# CITY OF ALBUQUERQUE

RE: **Lots 19Block 5 Volcano Cliffs Unit 22 SAD 228**  
**6620 Sujeto Rd. NW**  
**Grading and Drainage Plan**  
**Engineers Stamp Date; 9/10/2020 (D10D003K19)**  
**Pad Certification Date; 8/28/2021**  
**CO Certification Date; 9/30/2022**

Based on the Certification received 9/31/2022, this site cannot be accepted for release of Certificate of Occupancy by Hydrology until the following comments are addressed.

OLIVAS, JONATHAN (M. SANCHEZ) - GRADING & DRAINAGE PLAN

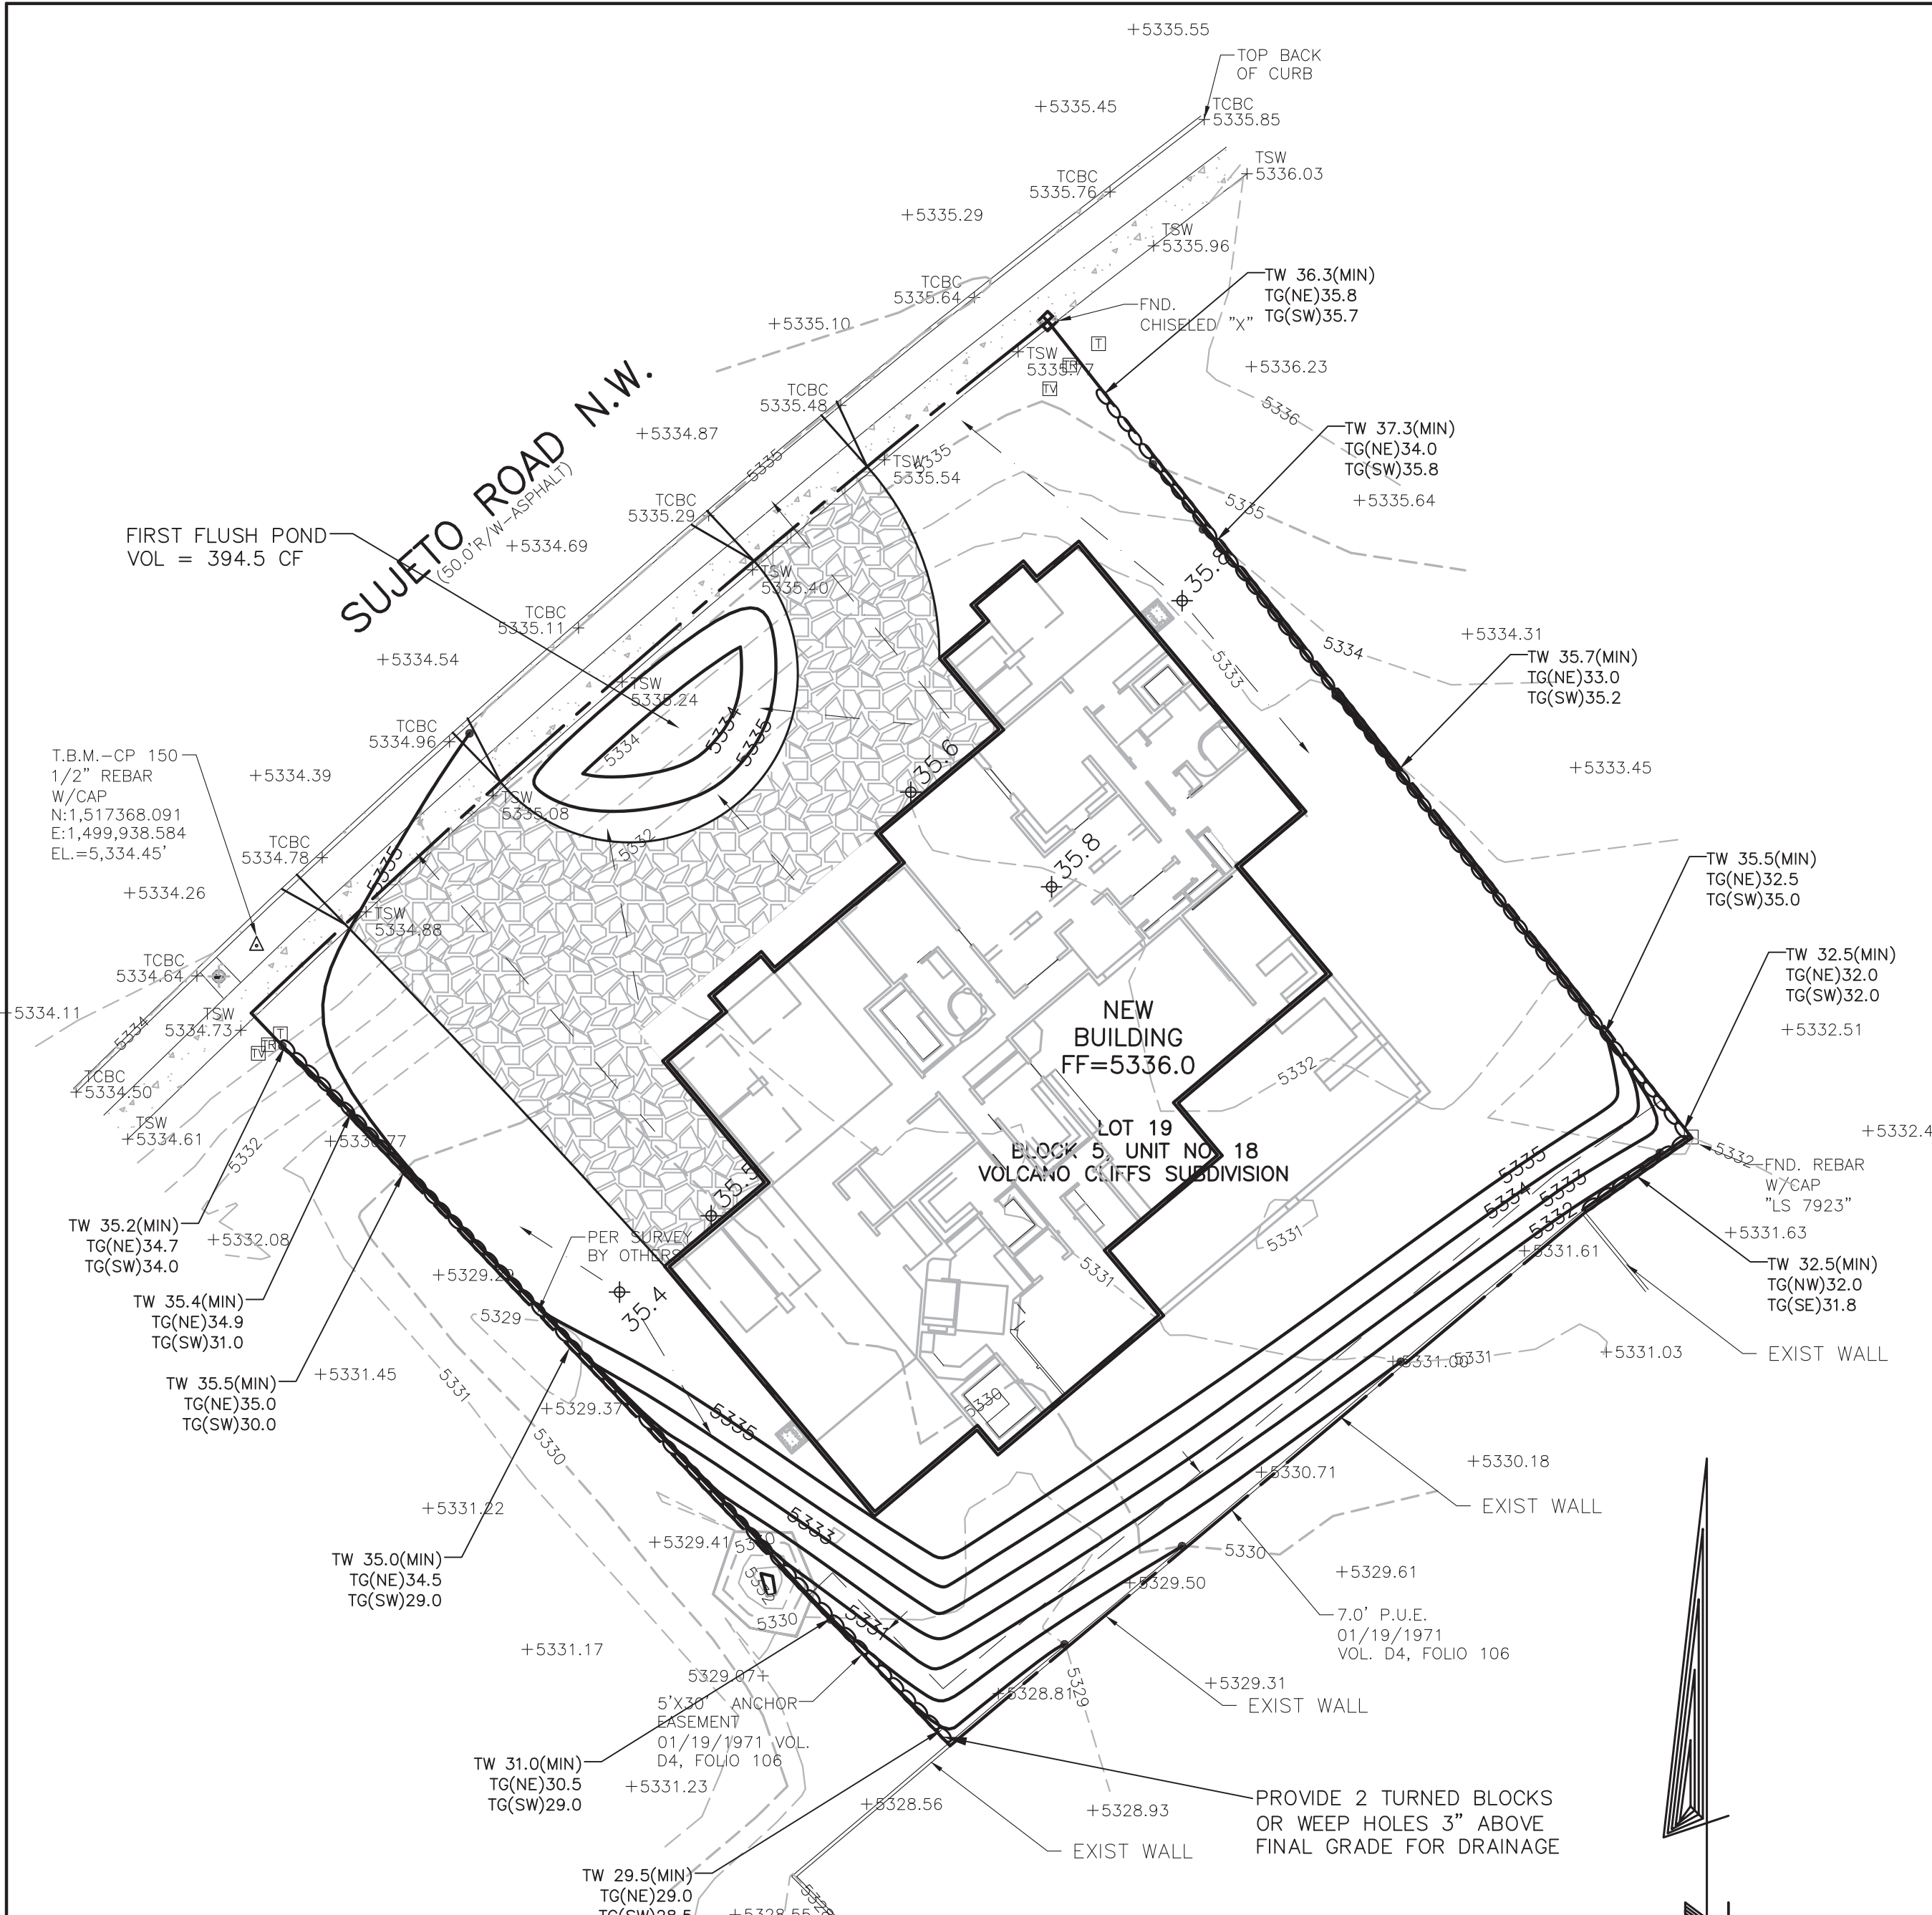
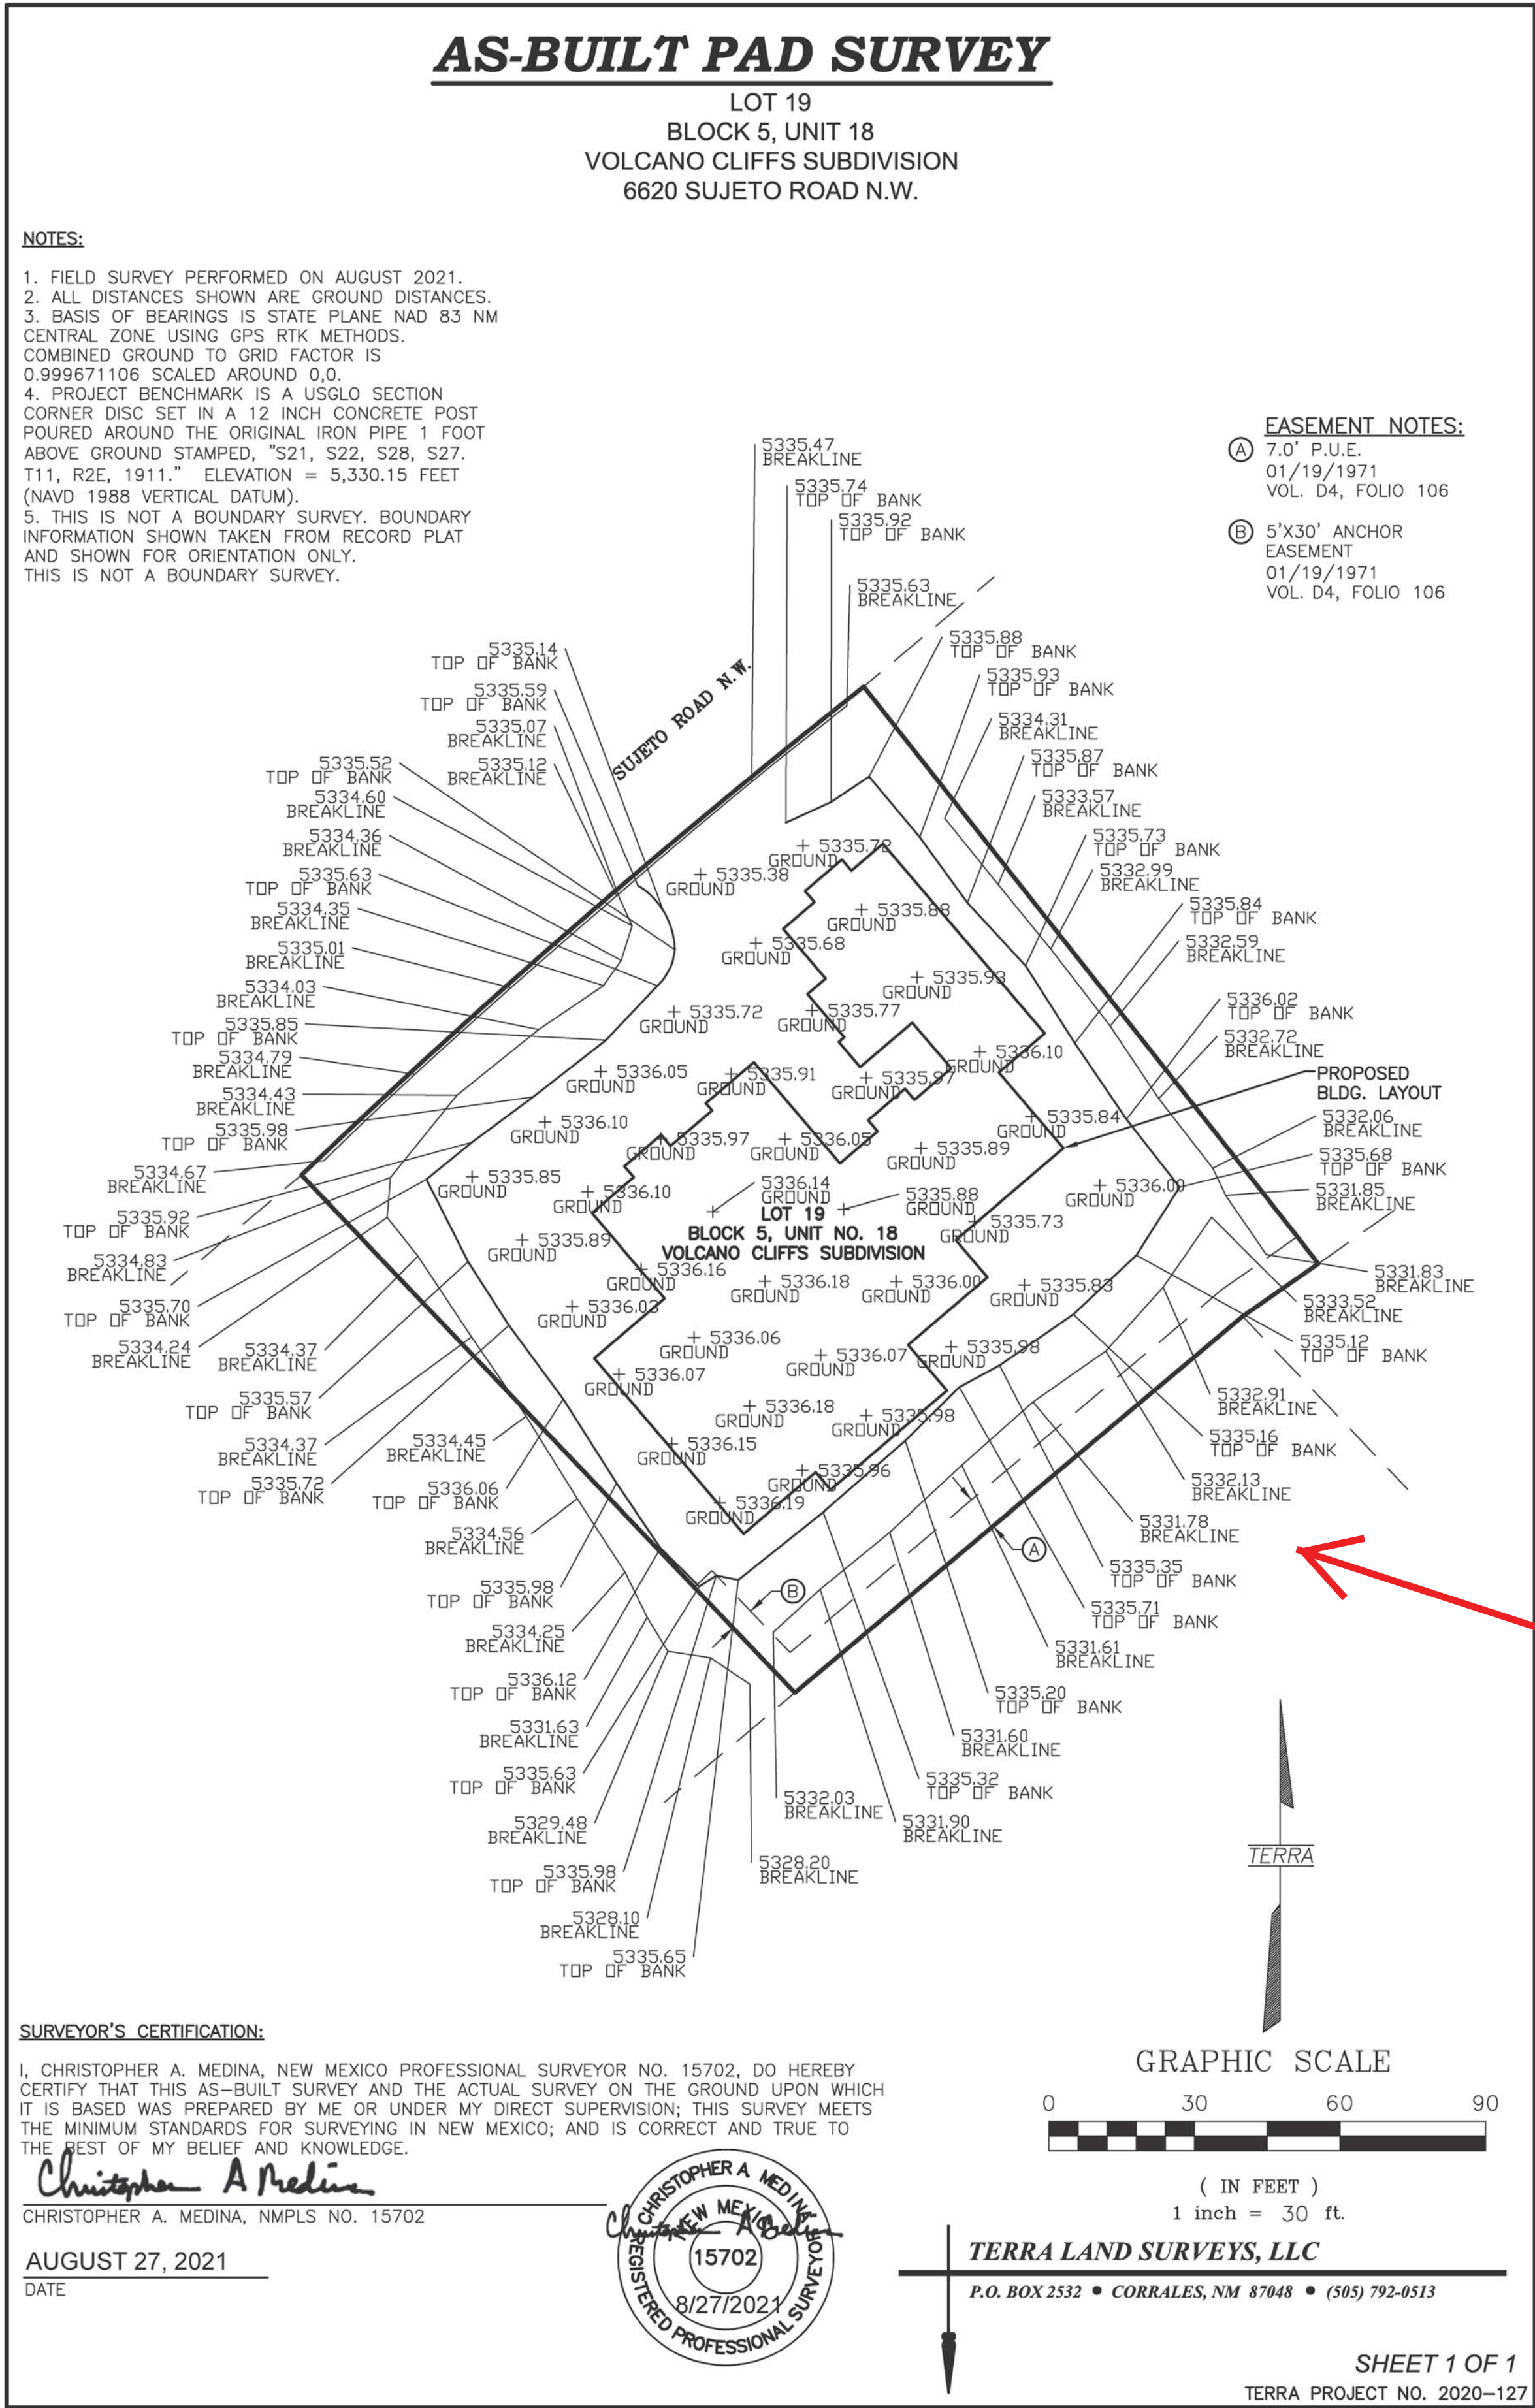
- The rear yard does not have erosion protection.
- Erosion protection needs to be placed against the east cmu wall, at least 2 feet high at a grade of 3:1.
- The cmu wall must be finished in the east yard or a pond placed in front of the opening with erosion protection.
